2024/0460

Land adjacent Berry Lane Cottage, Berry Lane, Howbrook, Barnsley, S35 7EJ

Erection of detached dwelling

Drawing No. SEA/902/G/006/A

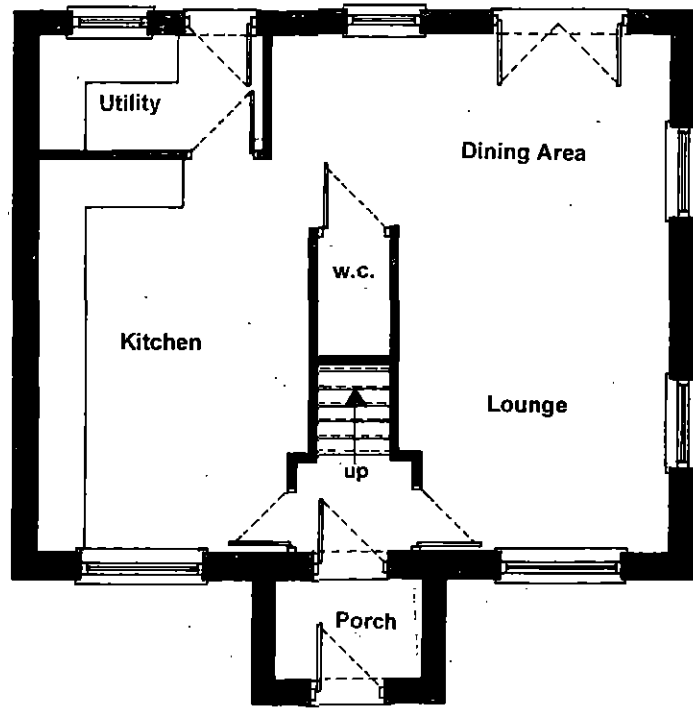
- The drawing number SEA/902/G/006 shows no designated parking or vehicle turning area for the proposed dwelling.
- The change from a small cottage to two family homes usually means four cars minimum. This would be a problem for any visitors or deliveries as there isn't space to park on the road.

With regards the parking drawing SEA/902/G/006 has since been updated to show a vehicle turning area as well as two parking spaces per dwelling which is in line with the parking SPD.

With reference to the amended site layout plan, the revised proposals now include two off-street parking spaces of sufficient size for the proposed dwelling along with room for vehicles to turn within the site, this is of considerable benefit in terms of highway safety. This turning provision, which enables vehicles to exit in a forward gear, also has the benefit of allowing sufficient intervisibility between drivers when vehicles are emerging from both accesses at the same time. In view of the above no objections are raised from a highway's perspective.
